**From:** Lynn Mazur, P.E., C.E.M.  
**Date:** November 11, 2004  
Development Review Engineer

**Subject:** Pyramid Concrete @ Comanche Business Park*G-16-DT37b***COMMENTS:**

Re: Pyramid Concrete, Grading & Drainage Plan, ZAP G-16  
Engineer's Stamp Dated 10-29-04

NEW BUILDING FOR PYRAMID CONCRETE	DRAWN BY BLN
	GRADING & DRAINAGE PLAN	DATE 7-24-04
	<i>Rio Grande Engineering</i>	SHEET #
	3500 COMANCHE ROAD NE BUILDING E, SUITE 5 ALBUQUERQUE, NM 87107 (505) 872-0999	JOB 04-1-HTI

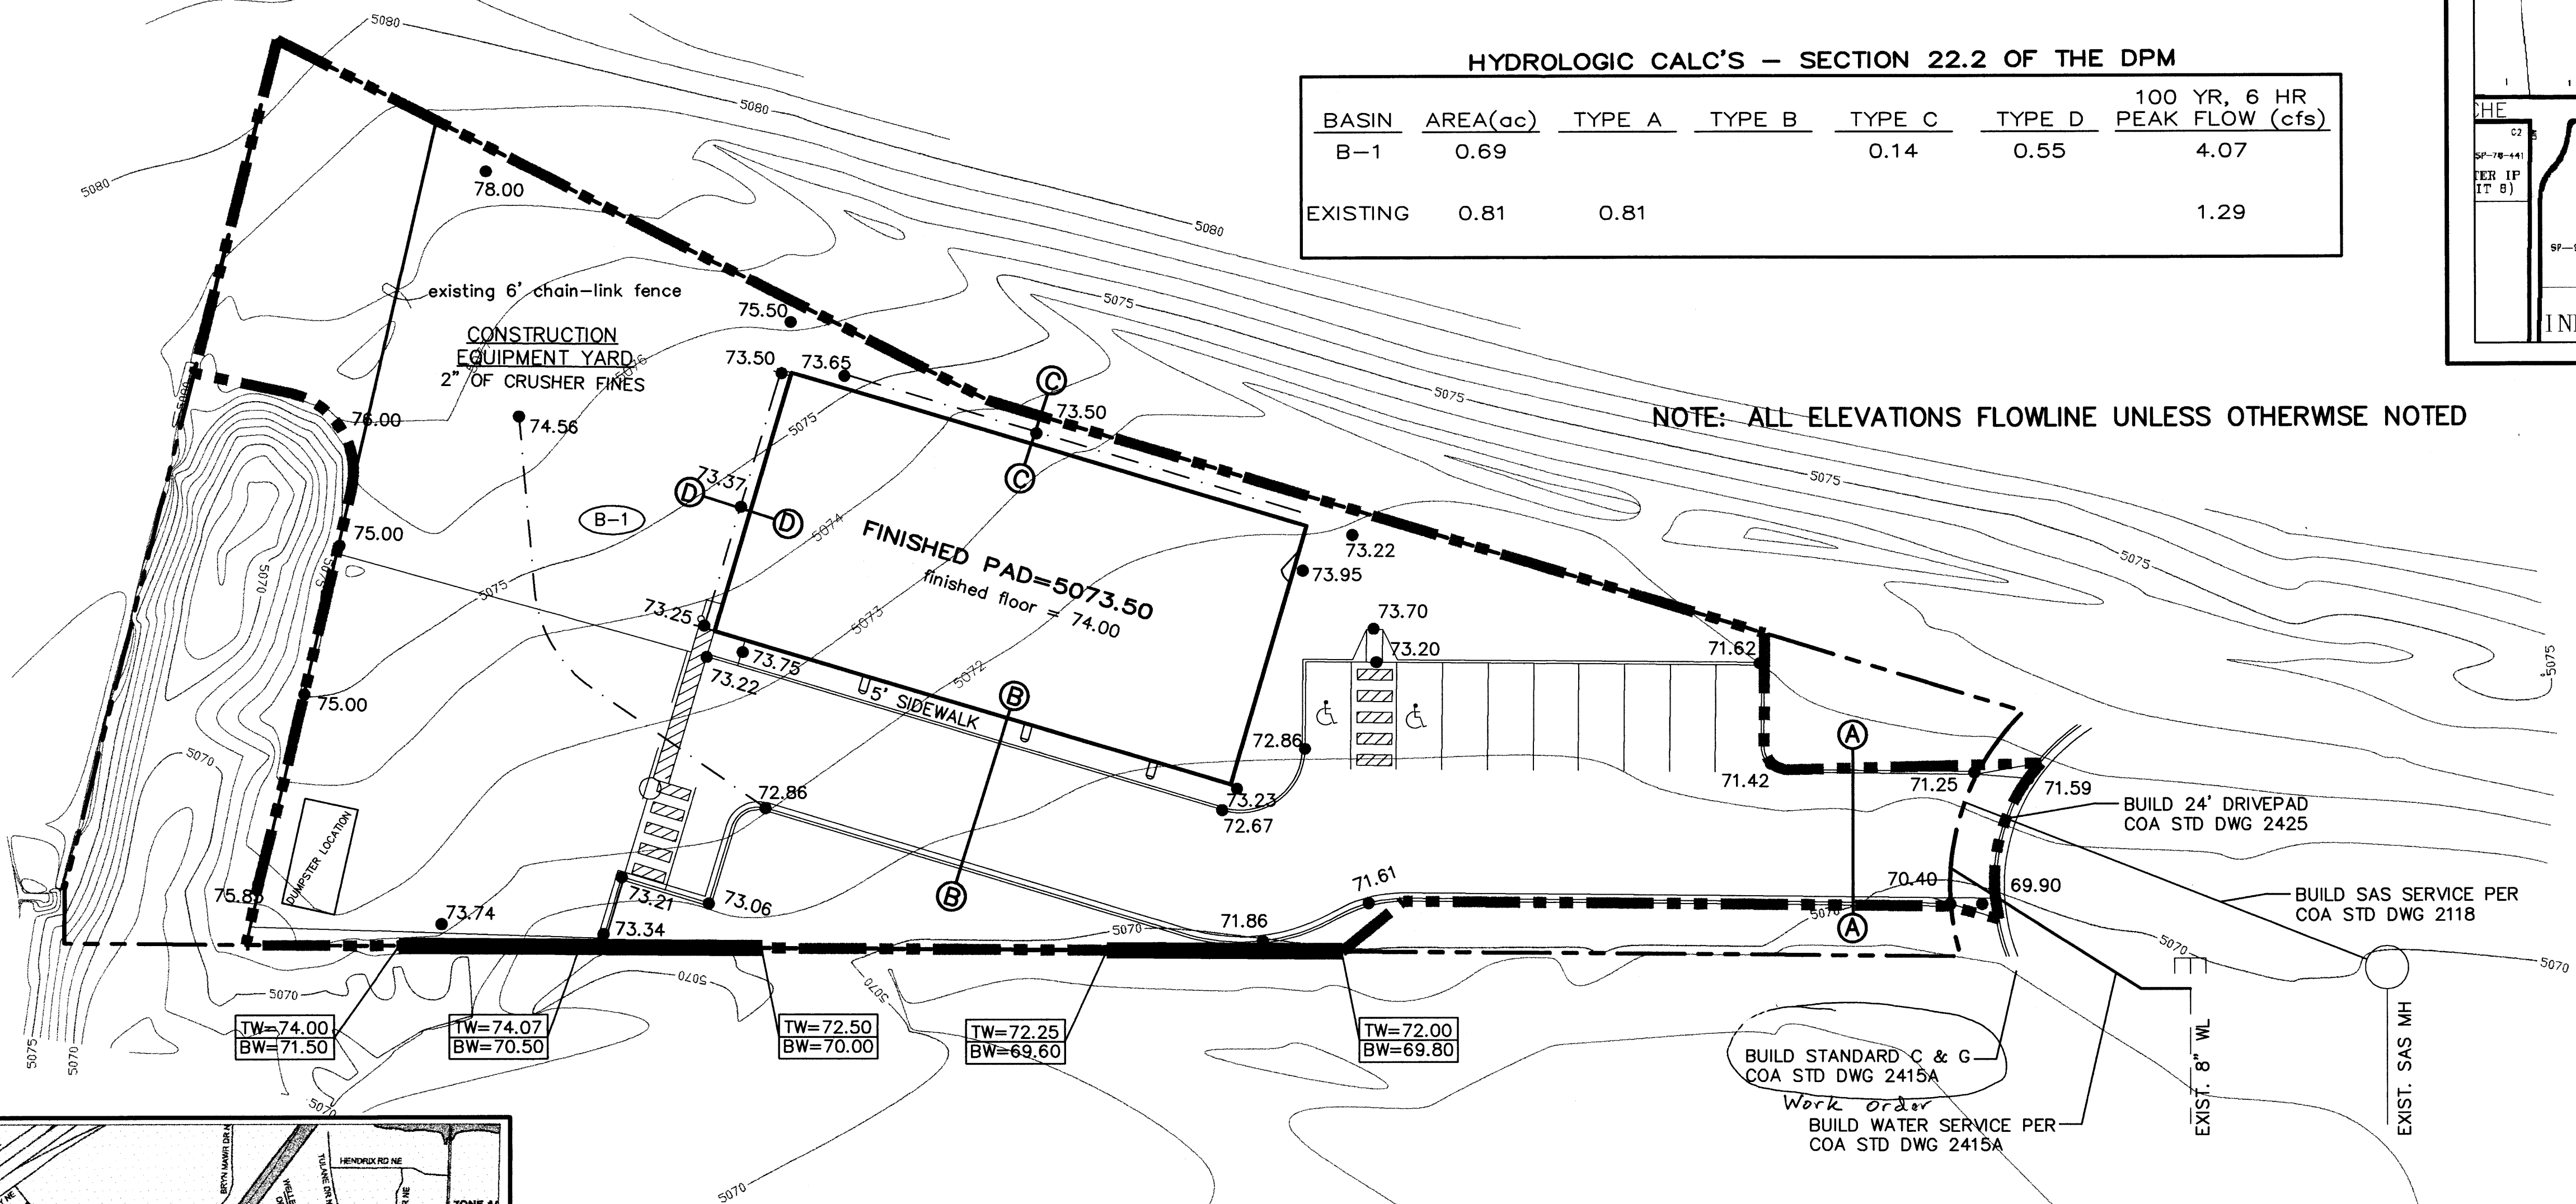
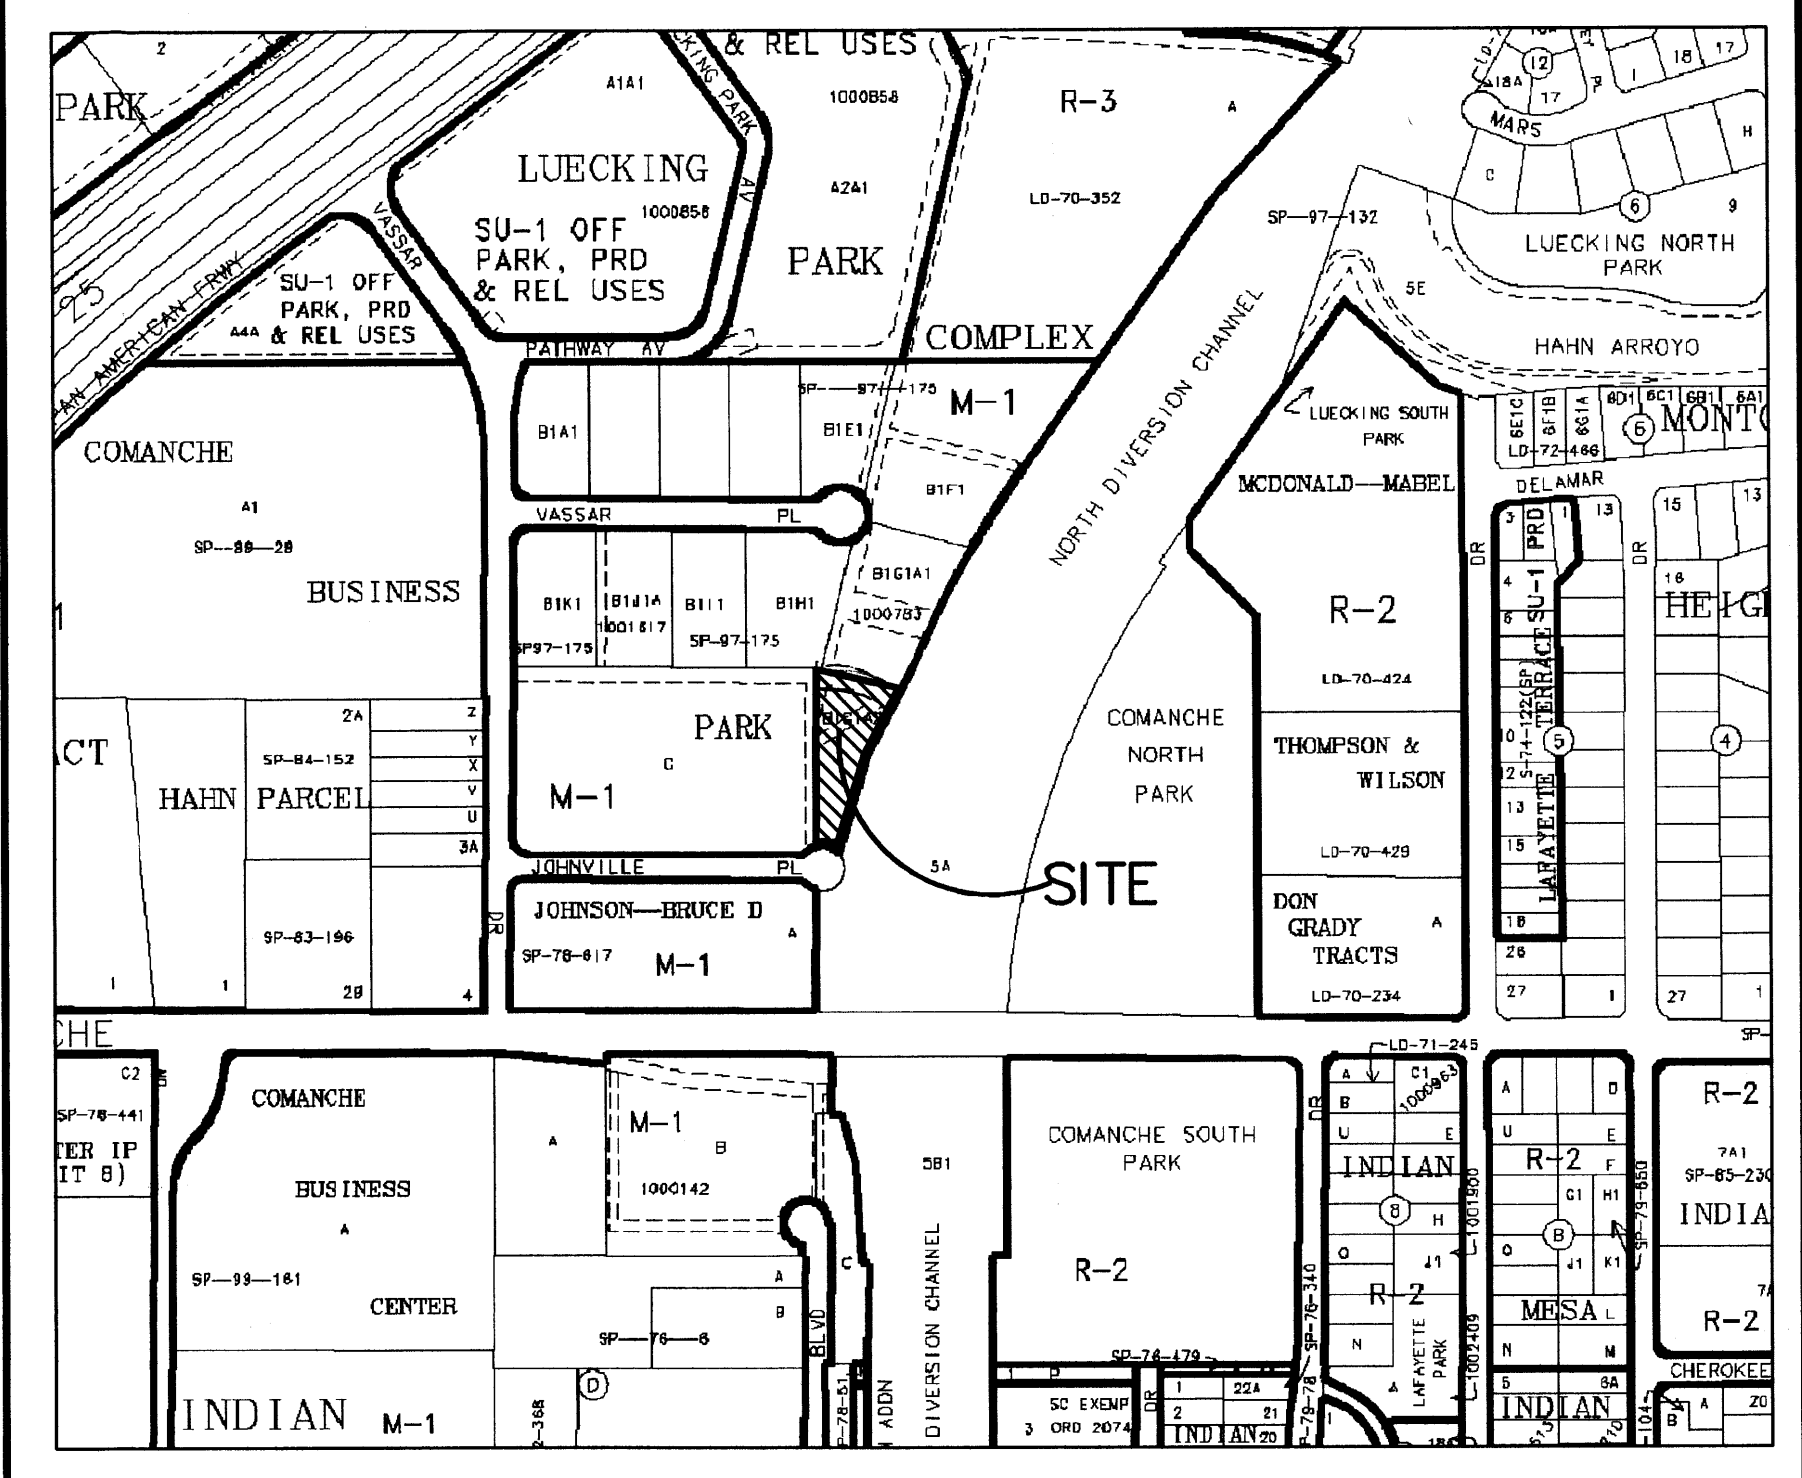
I pulled out the full size plan originally prepared by Jeff Mortensen for the pipe extension and noticed a SAS easement that was not shown on your G&D. John Kelly told me that the City installed a sanitary sewer line in the 36-inch storm drain crossing under the North Diversion Channel years ago without a permit from AMAFCA. It appears that the new Pyramid Concrete Building is encroaching into the easement. I am notifying the City by copy of this fax.

Also, what are you basing the pipe invert on at the existing junction box? It is about 2 feet higher than shown on the original plan, and it does not appear to be a datum difference. Add a note to match the existing invert. Also add a note to grout the concrete plugs for the removed 18-inch CMP's on both sides of the junction box.

AMAFCA has reviewed the referenced plan and does not approve release of building permit. I discussed the project with John Kelly, Executive Engineer, and we decided that the culvert extension must be constructed per the terms of the original agreement, dated August 2001 (see enclosed). The original survey shows 2-18" corrugated metal pipes, which will require removal and disposal. The new culvert extension will need to connect to the existing concrete junction box.
